# Boston Alternative Energy Facility

## Statement of Common Ground between Alternative Use Boston Projects Limited and Boston Borough Council

Planning Inspectorate Reference Number: EN010095

Date: ~~October~~ December 2021

DRAWING No. **PB6934-RHD-01-ZZ-DR-4021** SUITABILITY **S0** REVISION **0**

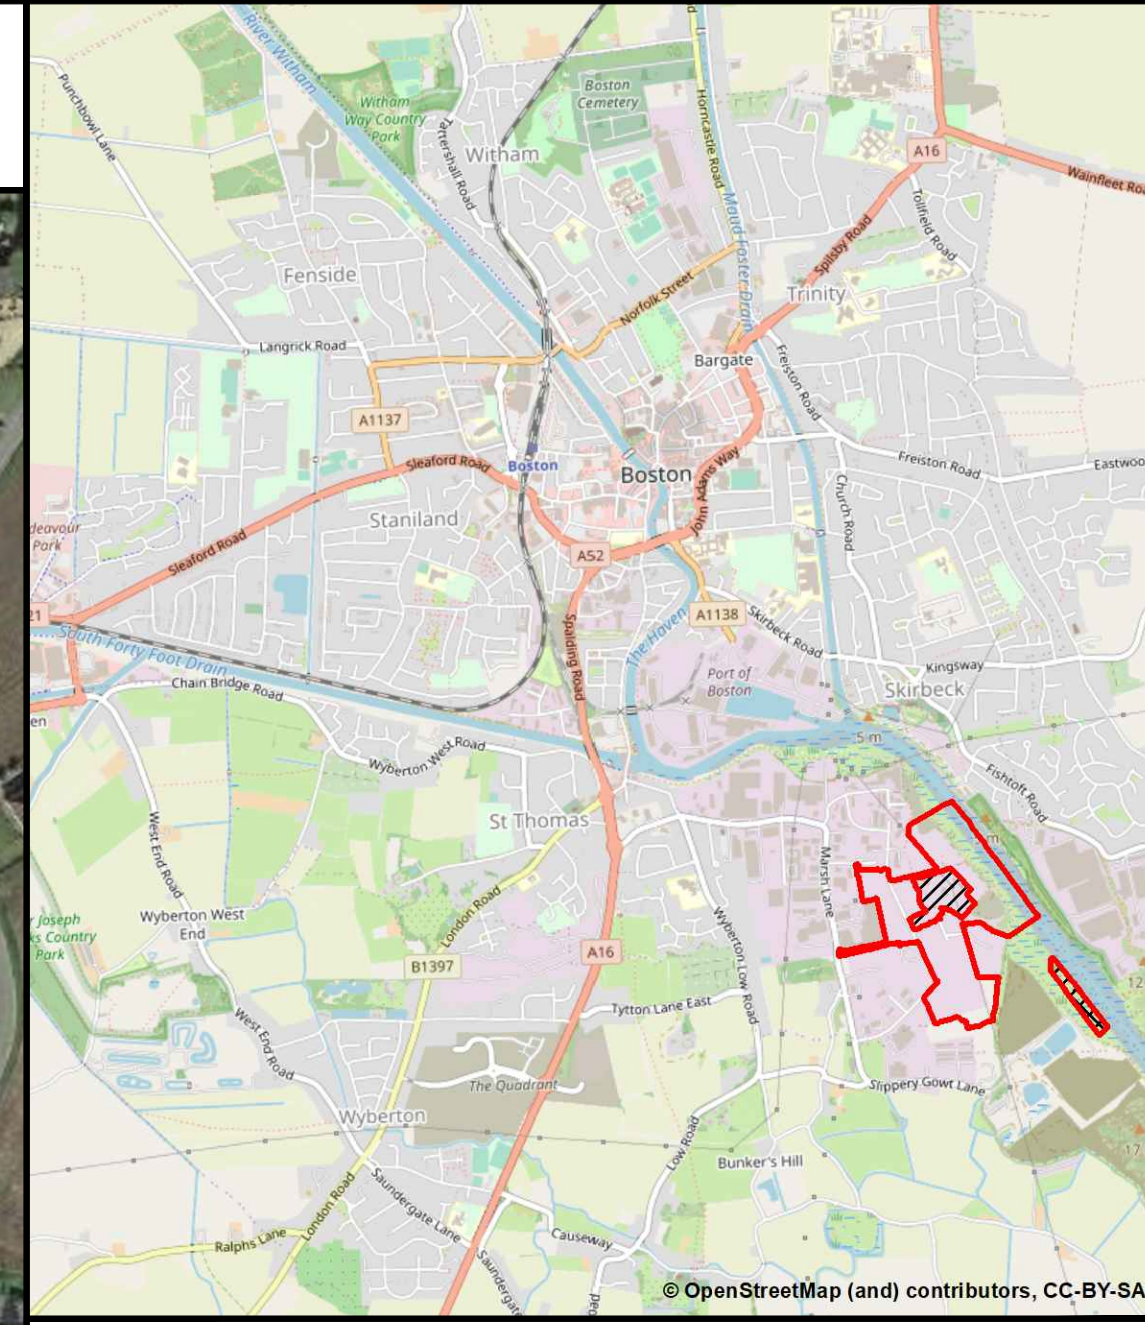
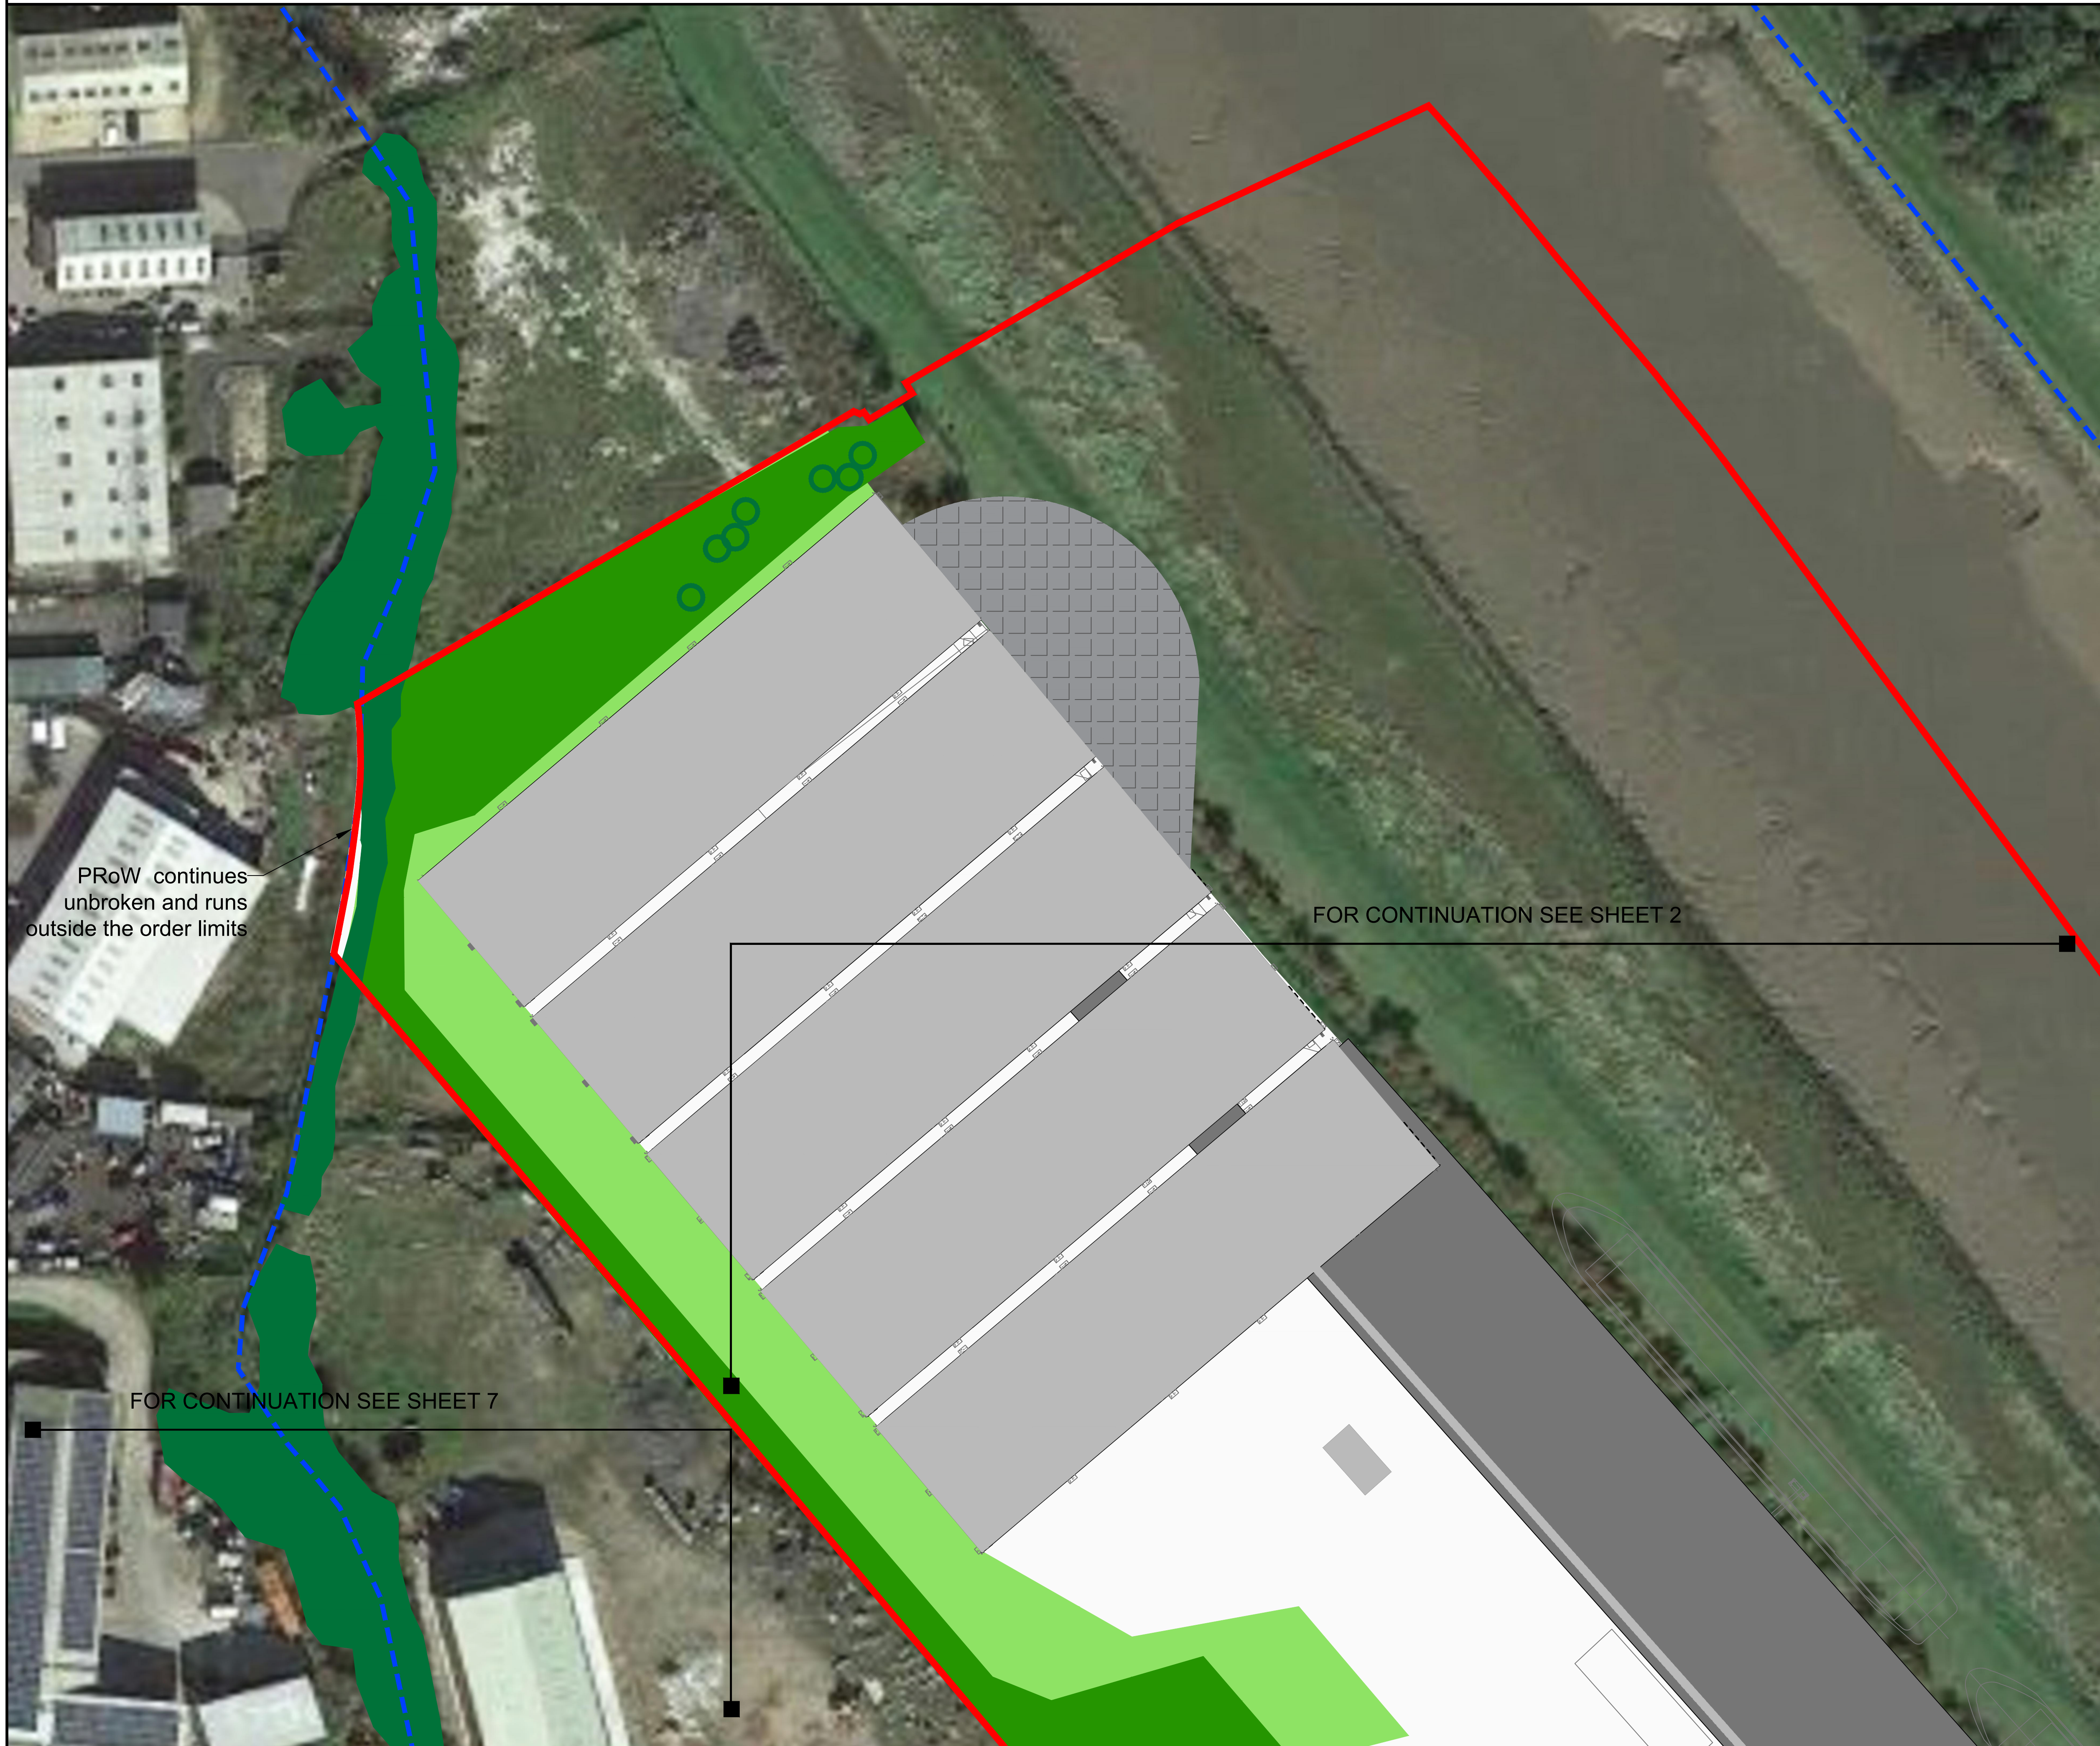
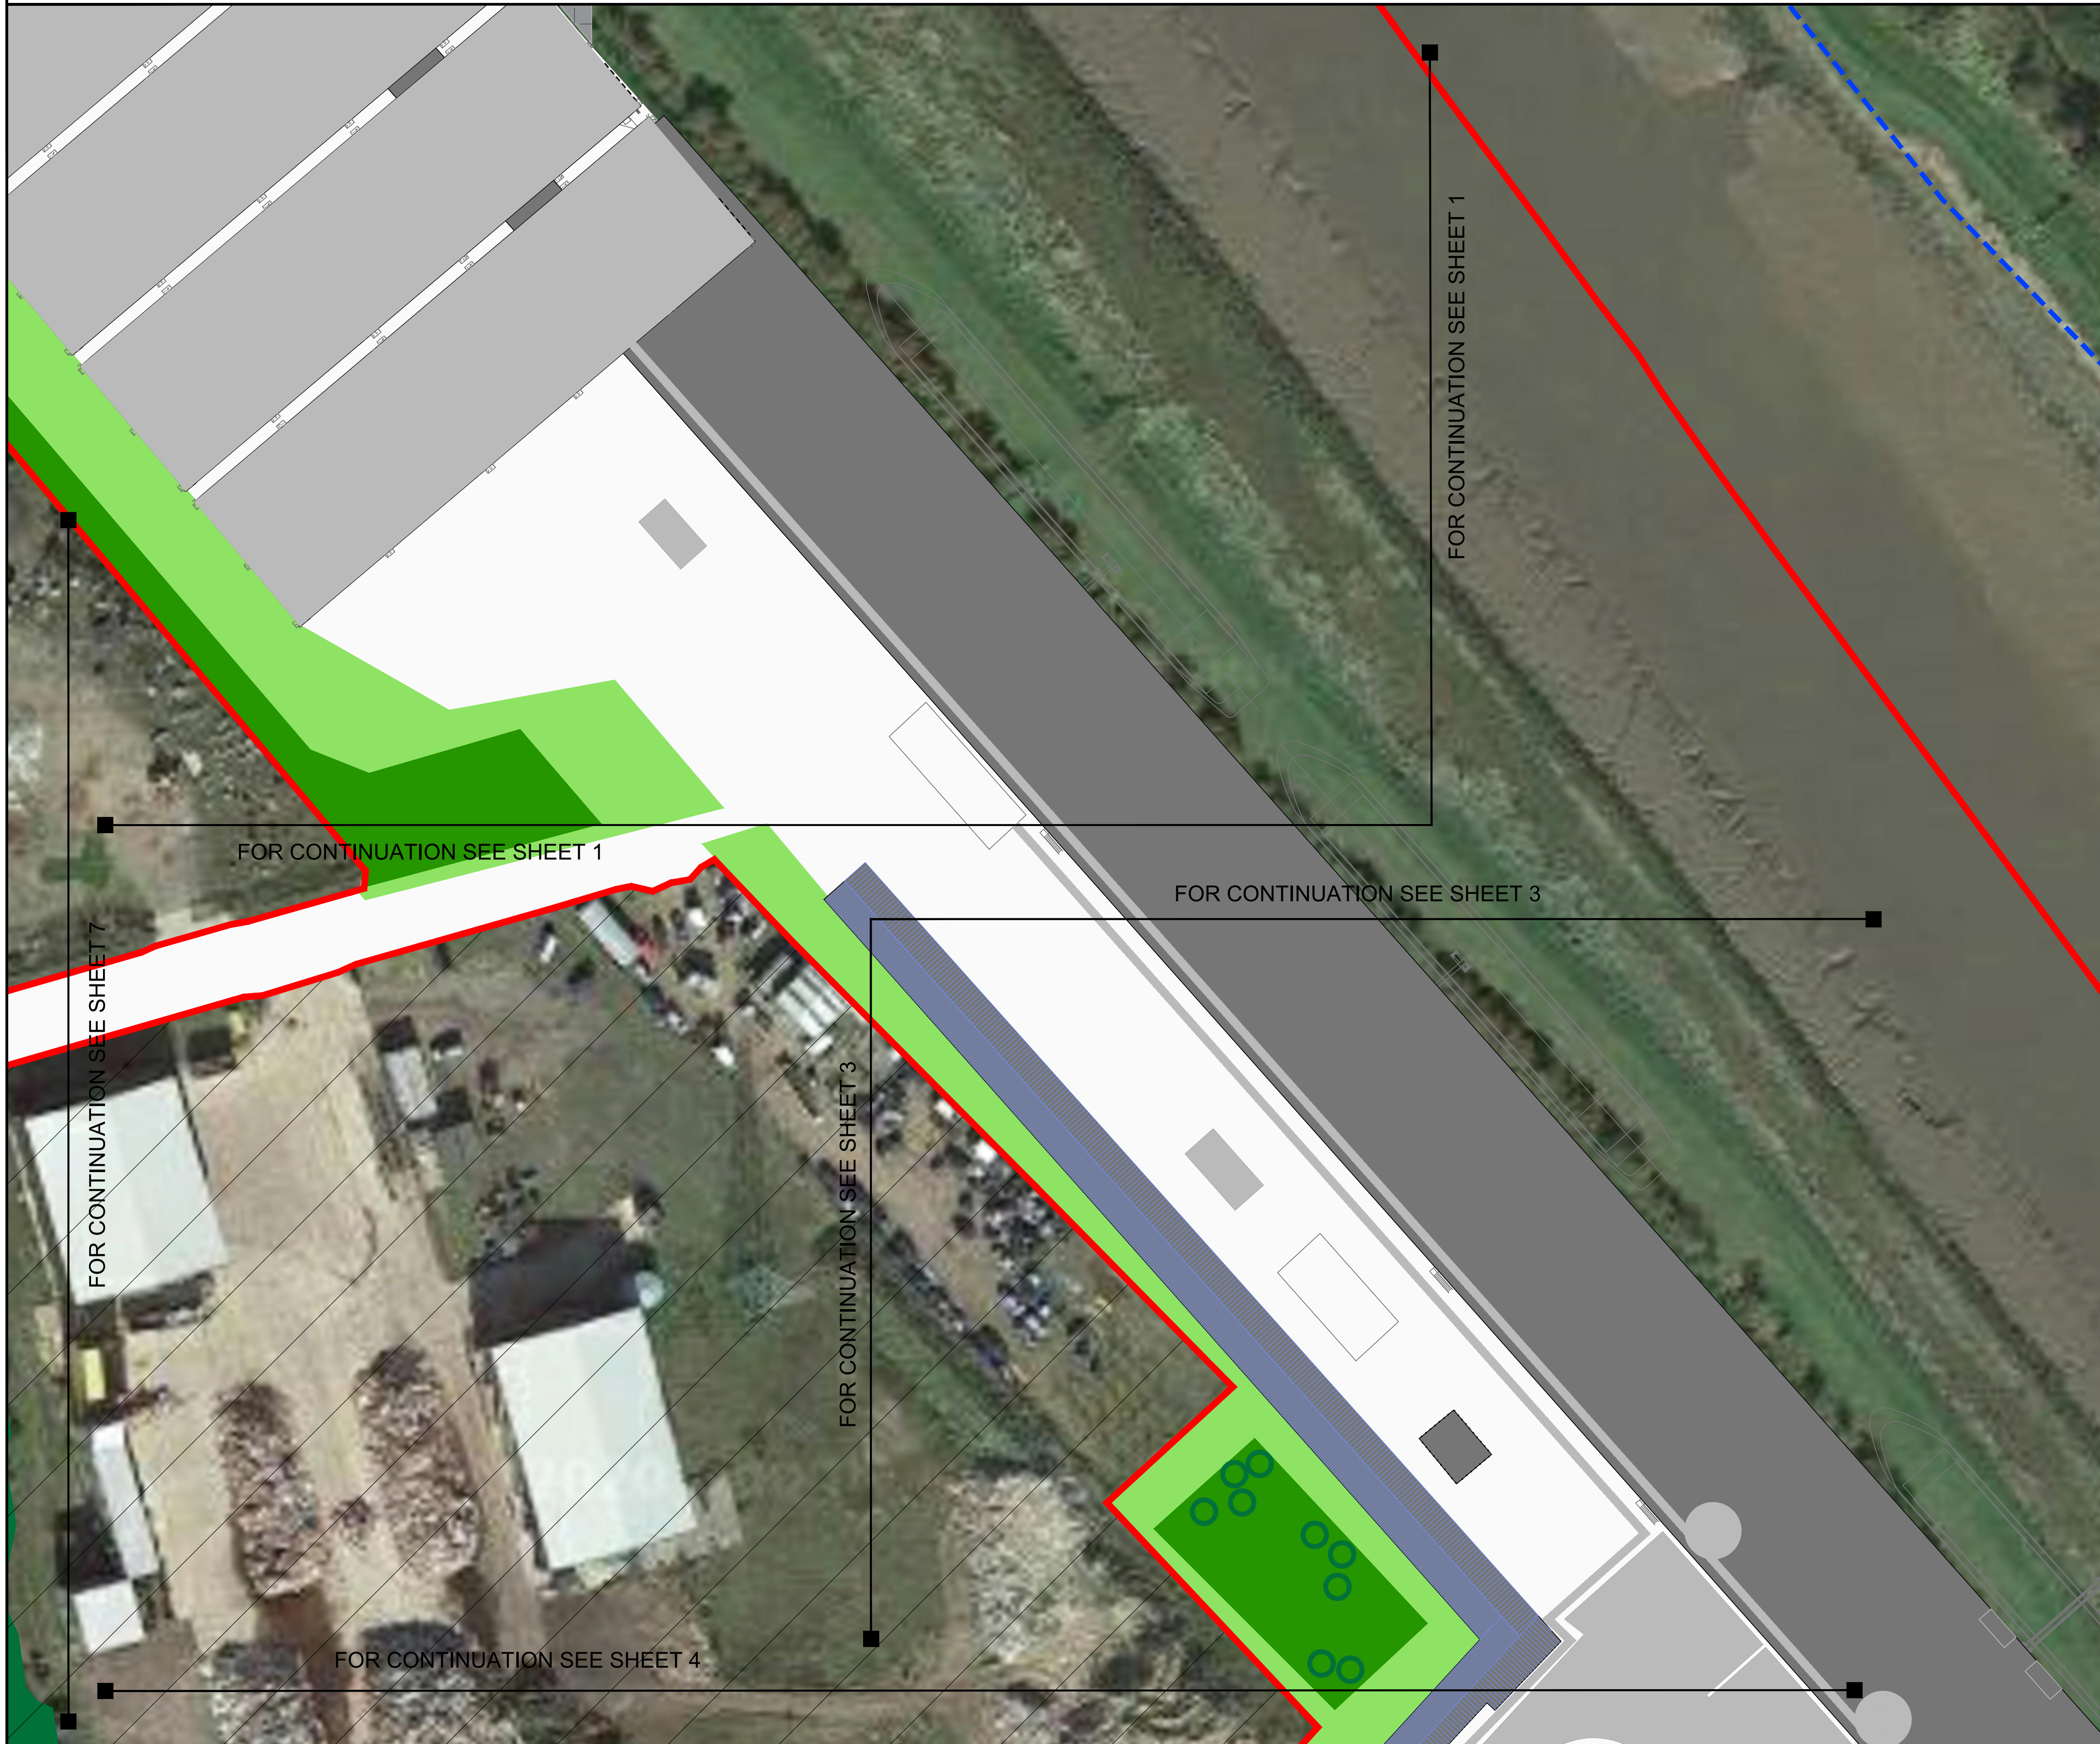
8.2	Draft DCO (document reference 2.1, APP-005)	Draft DCO	BBC seeks Article 23 (Tree Work) to be amended to add wording to ensure all necessary works are undertaken in accordance with BS5837 standards, and that in the event trees are required to be felled or removed, appropriate mitigation planting should be provided.	AUBP considers these matters are better addressed as part of the Landscape and Ecological Mitigation Strategy required under Requirement <u>65</u> of the draft DCO (document reference 2.1(2), APP-005 REP3-003). An Outline Landscape and Ecological Mitigation <u>Plan</u> Strategy (document reference 7.4, APP-123) was submitted with the application which details the proposed procedures in relation to site clearance and proposed planting. The Illustrative Landscape Plans (document reference 4.4, APP-014) show the locations of proposed planting.	Agreed
